Subject: Major Projects – Response to Submissions – Seniors Housing – IRT Woonona Redevelopment (SSD- 73910208) (Wollongong City)

Attachment A - CPHR Comments on Seniors Housing – IRT Woonona Redevelopment (SSD- 73910208) (Wollongong City) – Response to Submissions

FIGURE F50

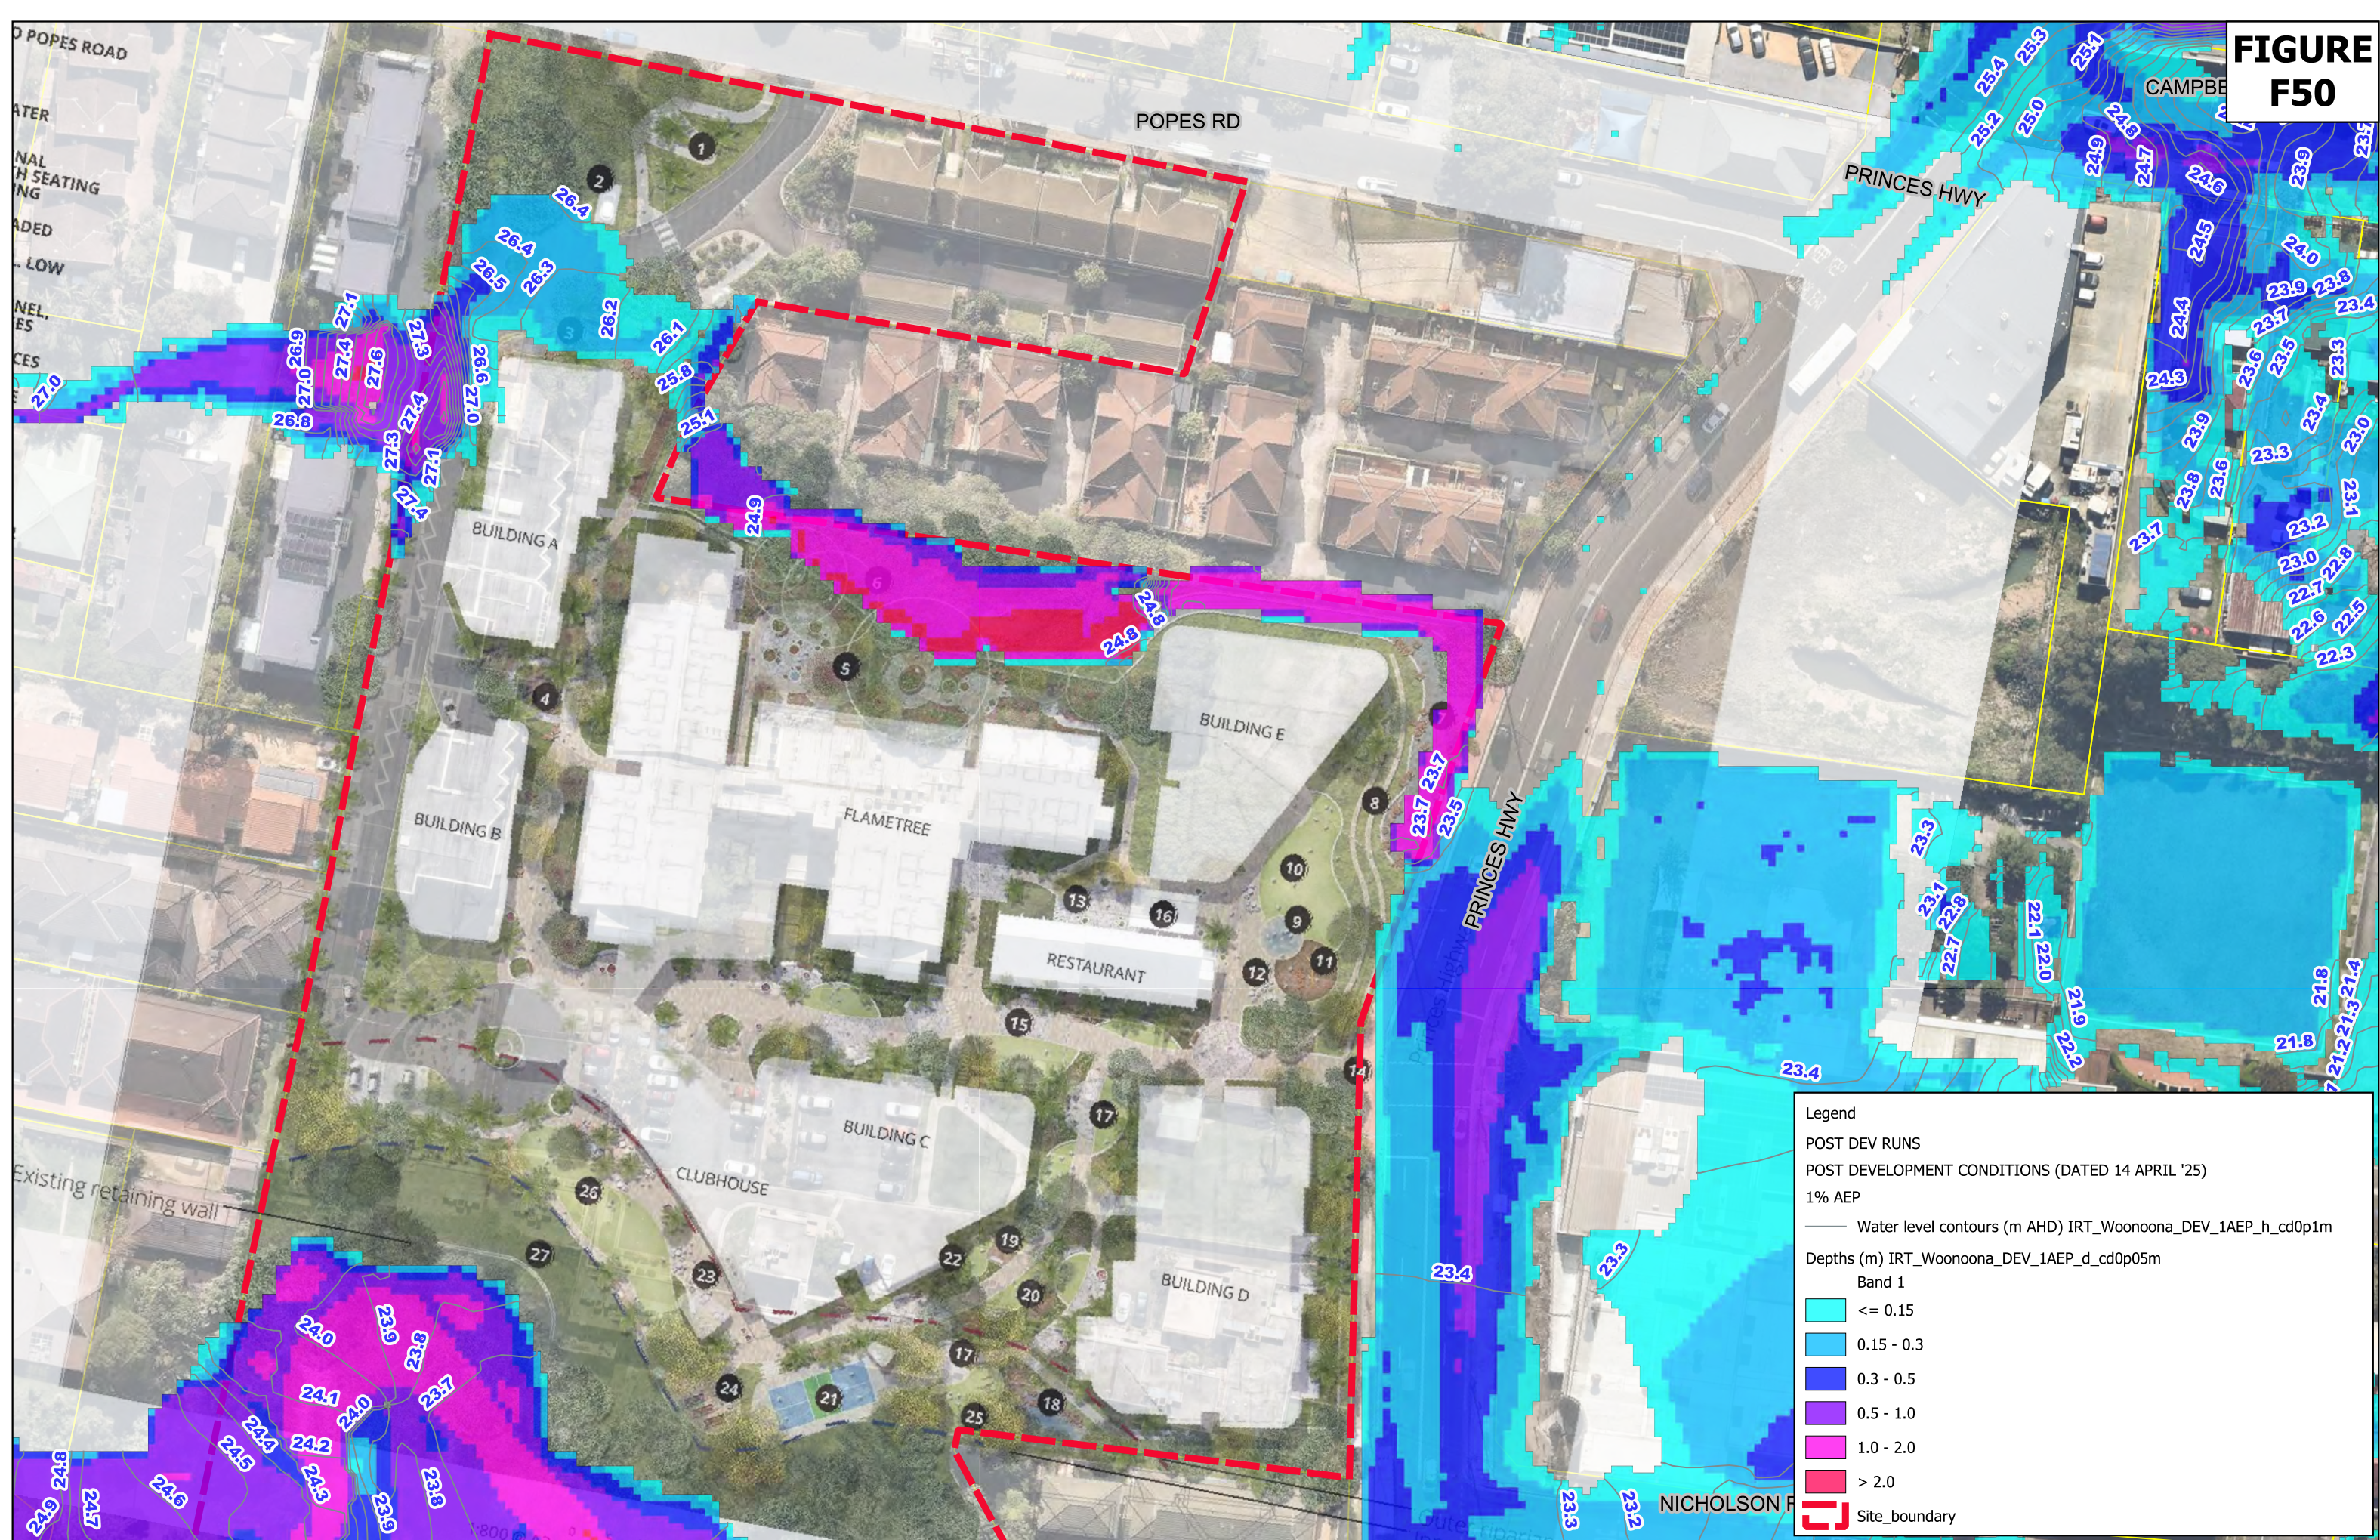
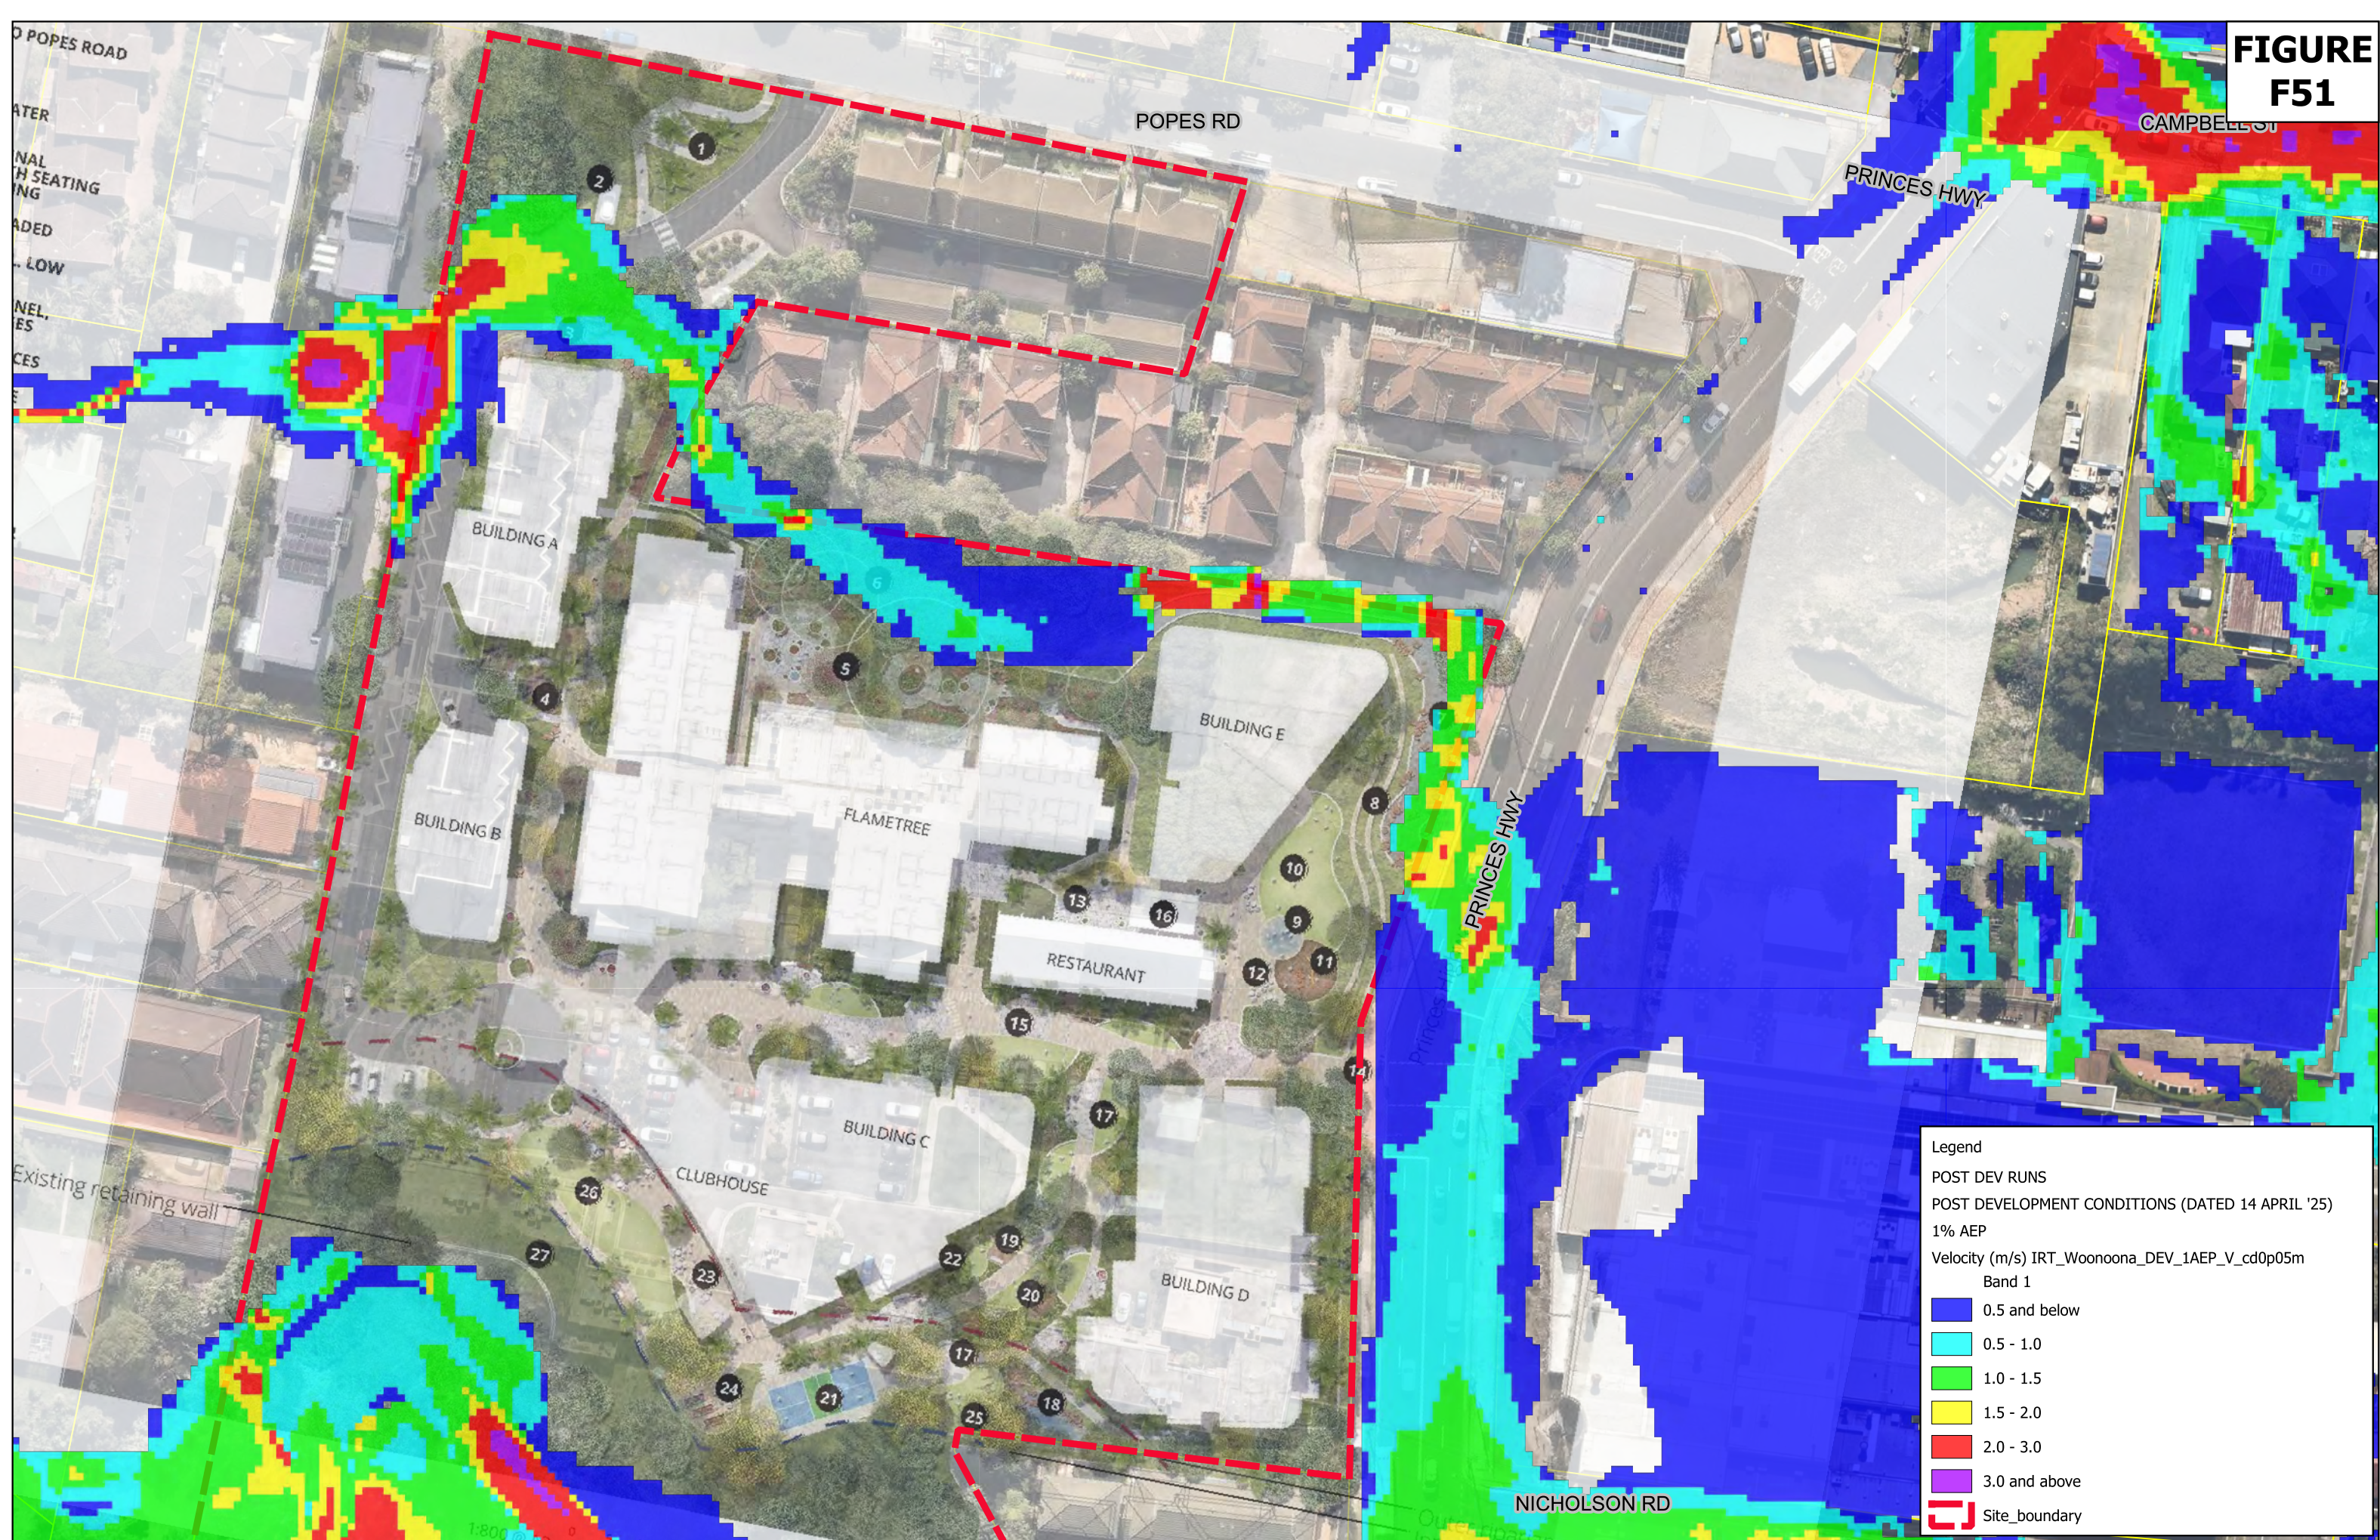
<p>CPHR Issue 2</p>	<p>Flooding</p> <p>The Flood Impact Risk Assessment maps provided in the initial Flood Report identified adverse flood impacts on Nicholson Road and Collins Creek in the 20% AEP event, and on the Princes Highway from the 10% AEP. The revised report indicates improved PMF levels with reduced impacts on proposed buildings.</p>
<p>Recommendation</p>	<p>Work with Wollongong City Council on managing its identified flood risk issues on site and consult with NSW SES on the final Flood Emergency Response Plan (FERP).</p>
